Our Ref: EN010068

**Application by Millbrook Power Limited for an Order Granting
Development Consent for the Proposed Millbrook Power Project**

Request for further information from all Interested Parties and the Applicant

Proposed Changes to the Original Application

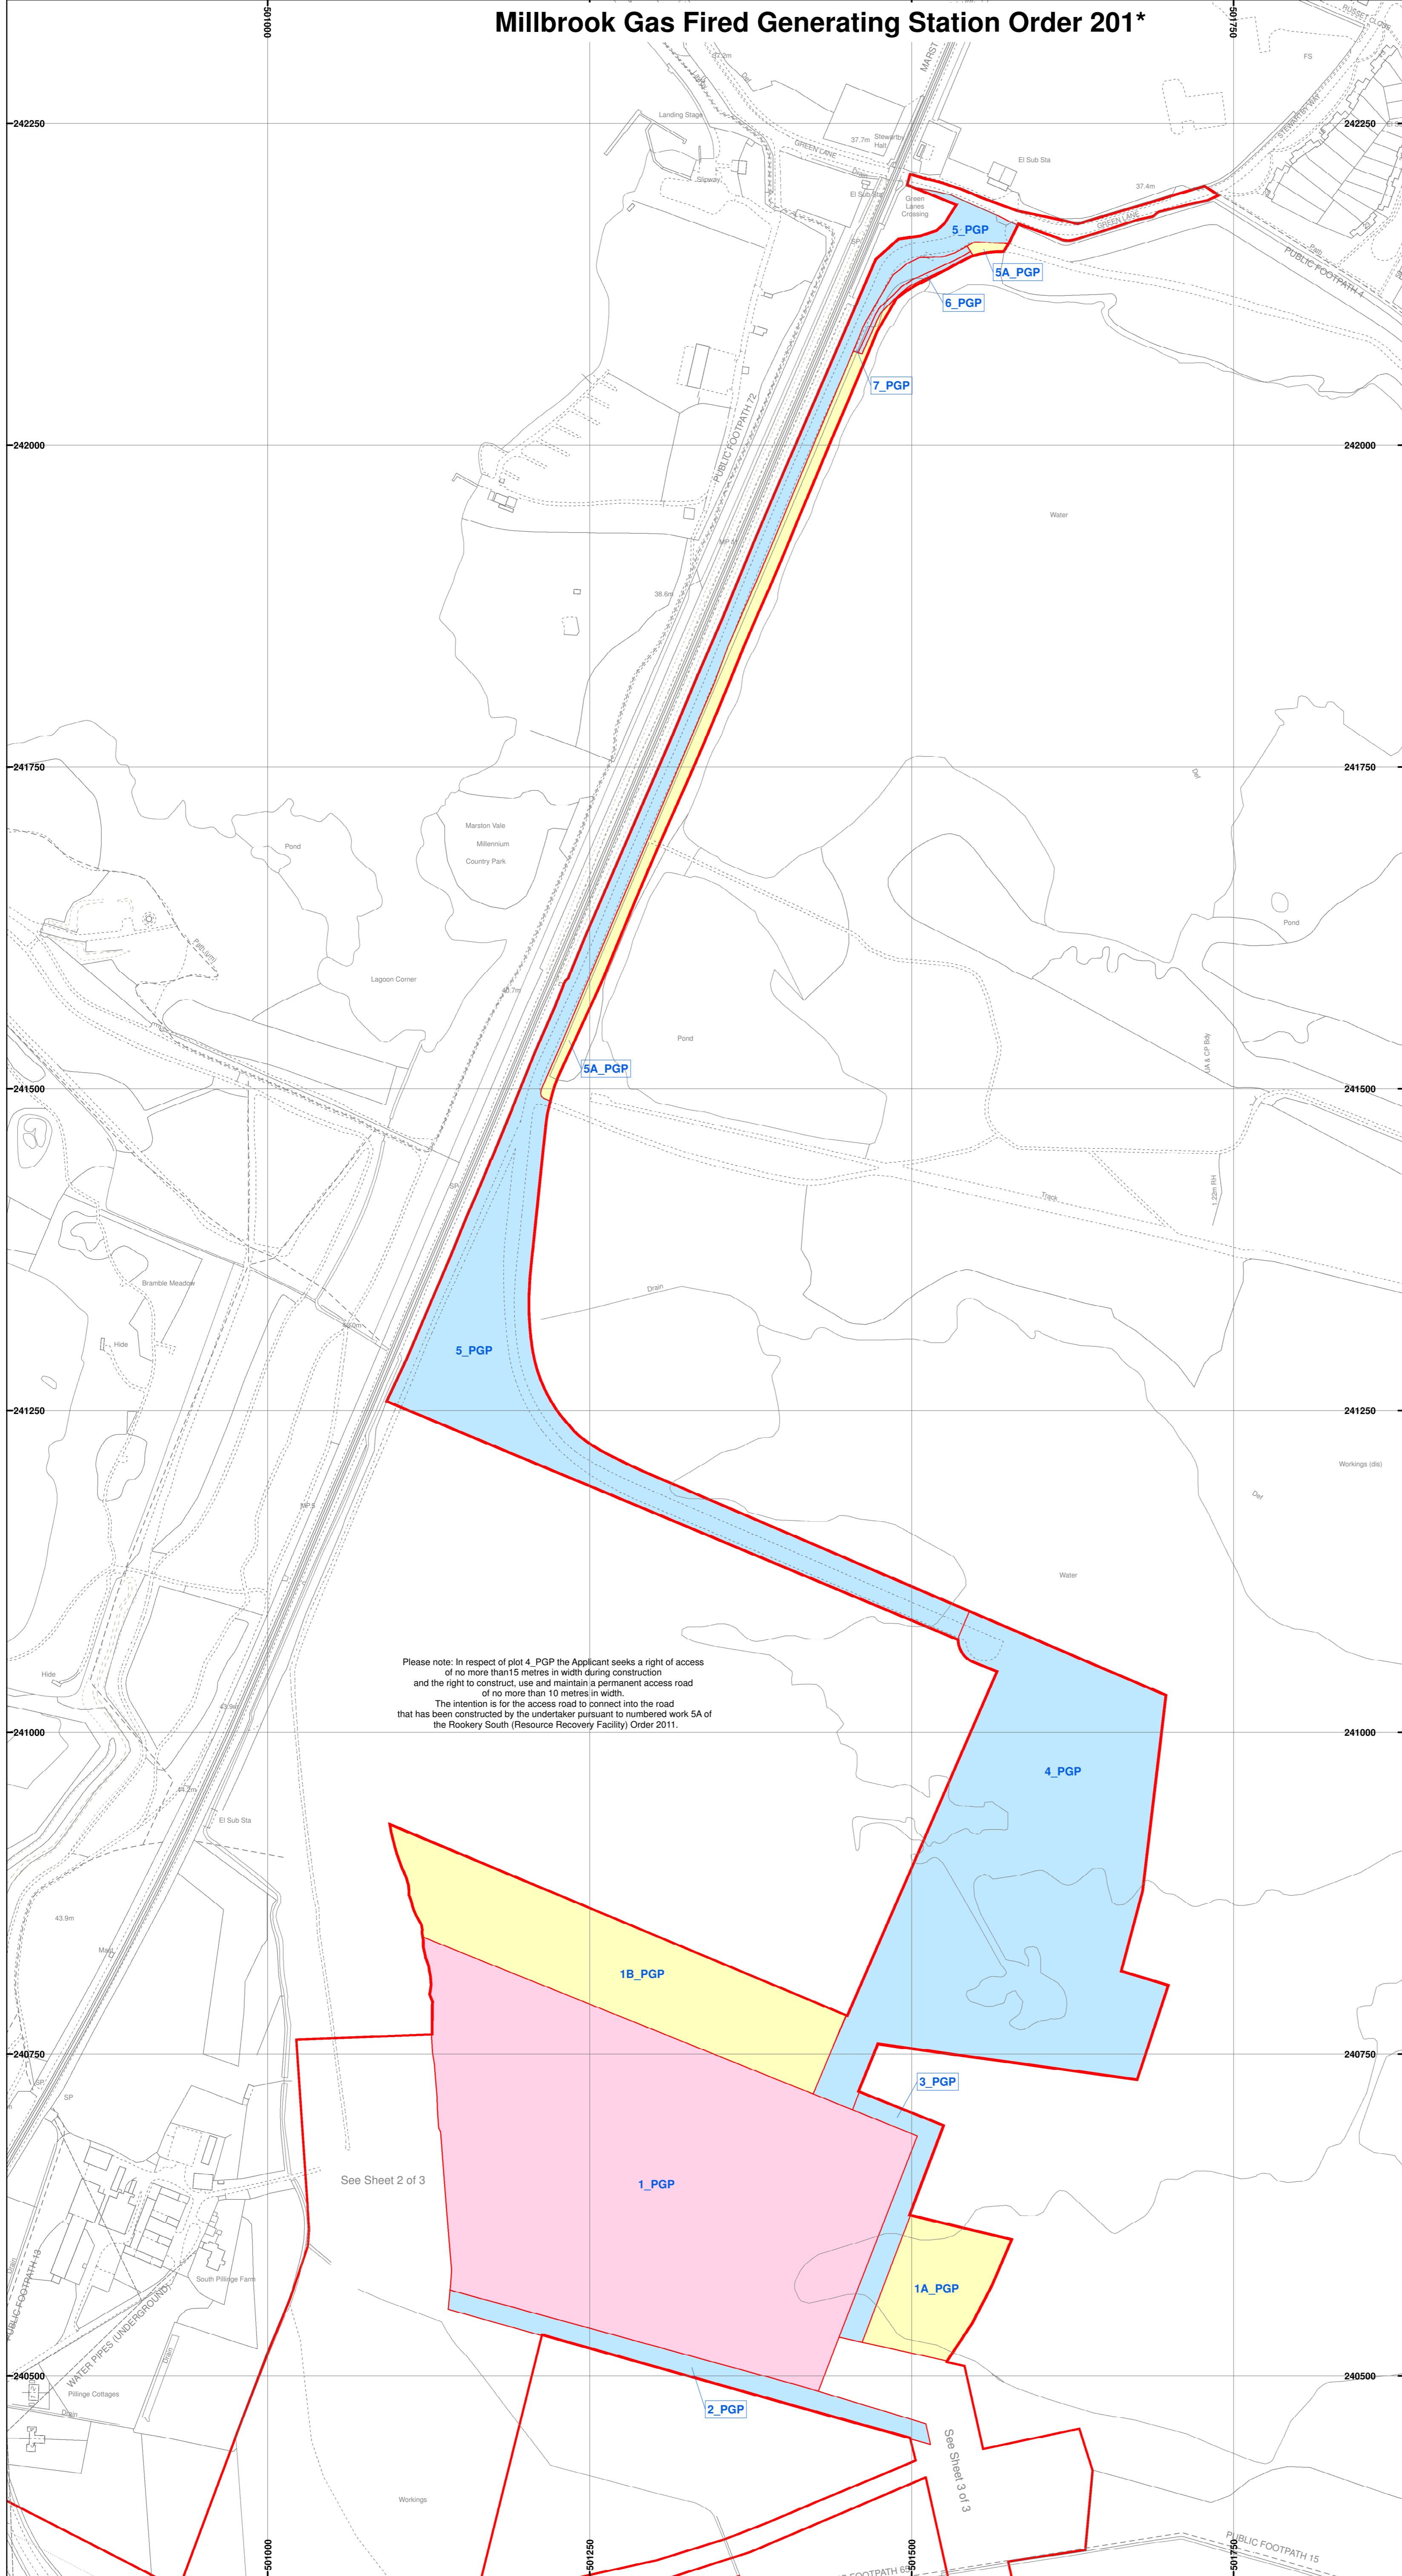
Sheet 1 of 3 in the Land Plans (Revision 1) submitted at Deadline 5 (J0008128-101 RevG) shows the revised plot 4_PGP. It notes that *"In respect of Plot 4_PGP the Applicant seeks a right of access of no more than 15 metres in width during construction and the right to construct, use and maintain a permanent access road of no more than 10 metres in width."*

Question for the Applicant - Please will the Applicant explain why it is seeking powers of compulsory acquisition over the whole of revised plot 4_PGP which appears to be larger than is required to provide the proposed access route?
